Sewall Wetland Consulting, Inc.

January 24, 2019

RE: 5637 East Mercer Way – Parcel #1924059312
City of Mercer Island, Washington
SWC Job#14-206

ESA Memorandum dated October 17, 2108

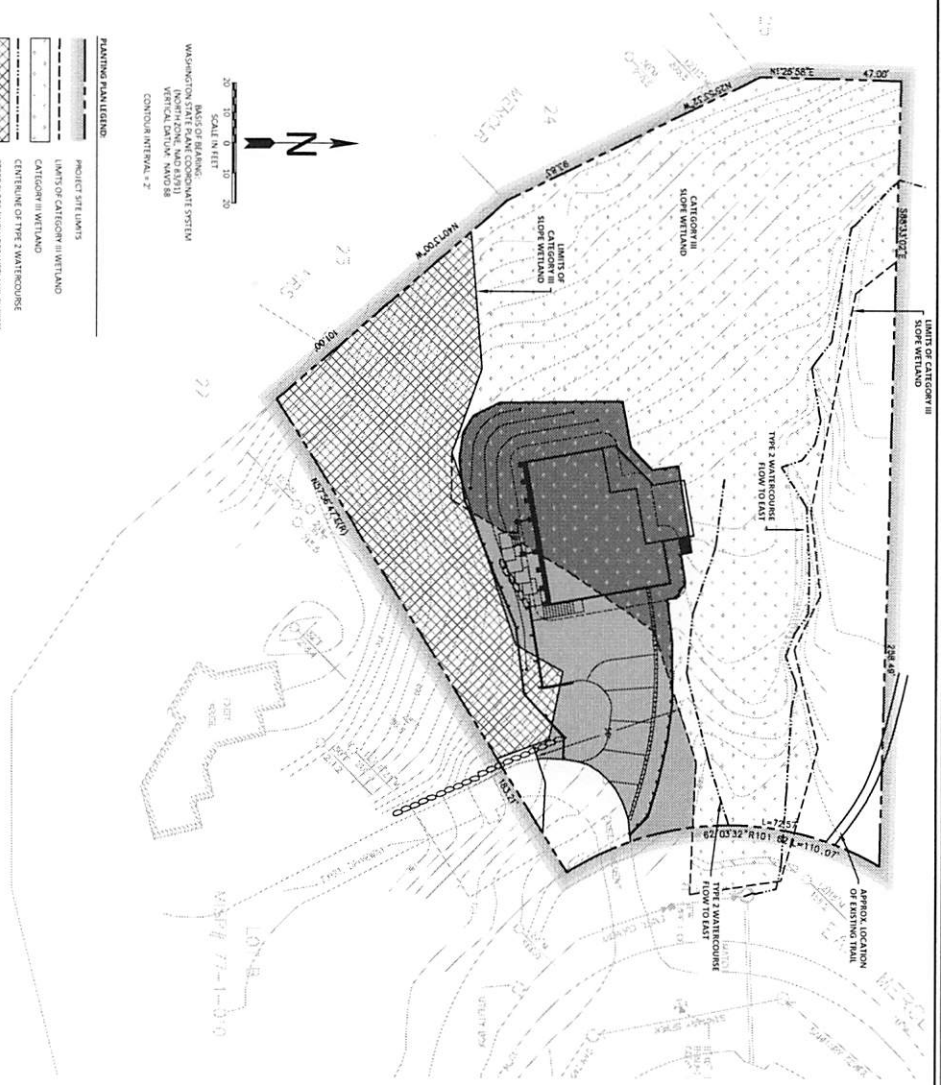
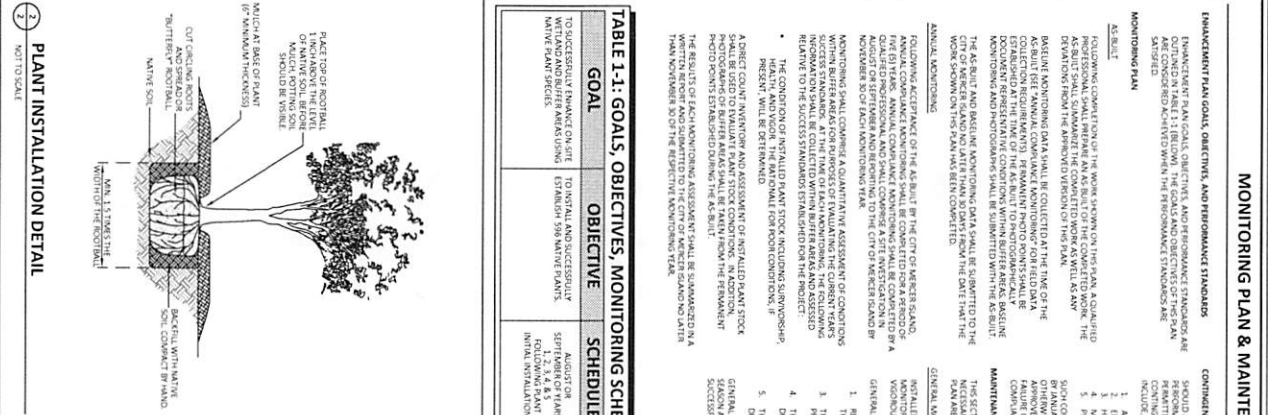
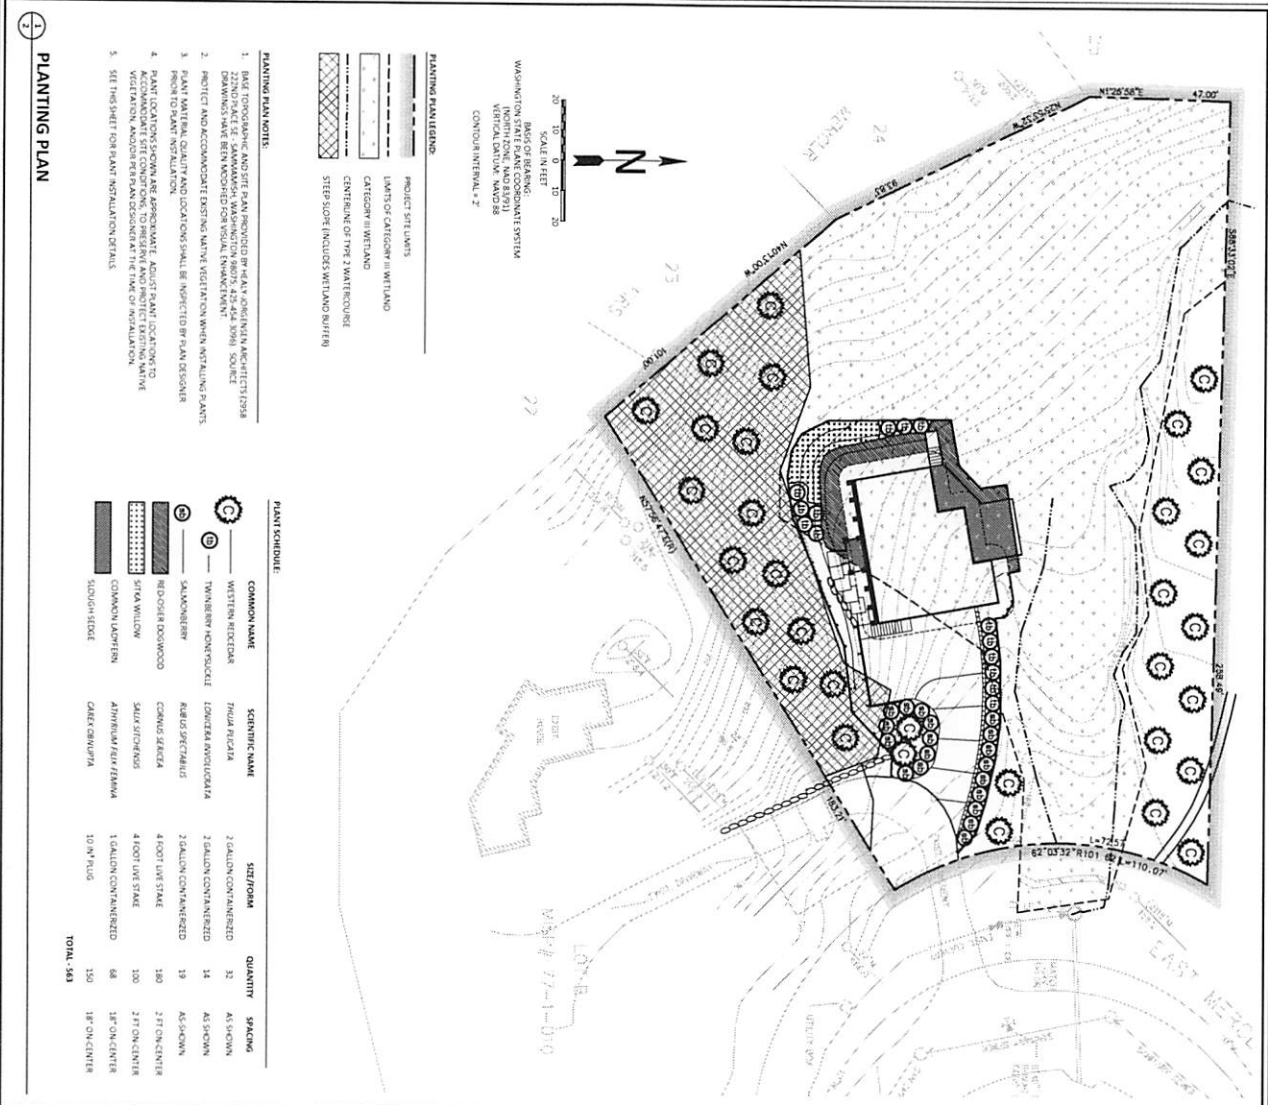
1. The March 8th CAR should indicate why the northeast corner of the building footprint is considered temporary and not permanent wetland impact.

2. Provide rationale to support the determination that decks will result in temporary, rather than permanent, wetland impacts.

3. The entire square footage of the northern deck should be considered as impact.

5. The applicant should provide detailed discussion and associated impact calculations, if applicable, of the proposed excavation and grading activities. Grading should be designated as permanent wetland impact and mitigated appropriately.

7. If the area encompassed by the perimeter fence or wall will be permanently disturbed, then appropriate mitigation should be implemented based on the impact area.

8. A house maintenance area should be calculated and mitigated.

11. Include the northern retaining wall in the impact area calculation.

14. Mitigation discussion within the CAR should clarify the type of onsite mitigation.

15. Mitigate onsite to compensate for permanent buffer impacts.

Response: The area of the northeast corner of the site is now considered a permanent impact on the attached revised mitigation plan.

Response: Although we are proposing to replant the area under the decks, for the purpose of the impact calculations, we now are including

the decks as an impact. This area will now be replanted with slough sedge as a mitigation action

Response: As requested, all structures and grading are now considered a permanent impacts as shown on the attached Wetland and Buffer Impact Site plan dated revised 12-17-18.

Response: The retaining wall is now considered a permanent impact.

Response: A 5' BSBL area has been calculated as an impact as requested.

Response: The northern wall has been calculated as a permanent impact.

Response: The mitigation for the project will consist of two actions;

1. On-site buffer enhancement to include under planting the existing buffer with conifers, as well as replanting areas that are graded

and under the elevated decks. This is depicted on the attached Critical Area Enhancement Plan revised to 1-24-19.

Response: On-site wetland buffer enhancement includes removal of any blackberry and under planting with conifers as depicted on the attached Critical Area Enhancement Plan revised to 1-24-19.
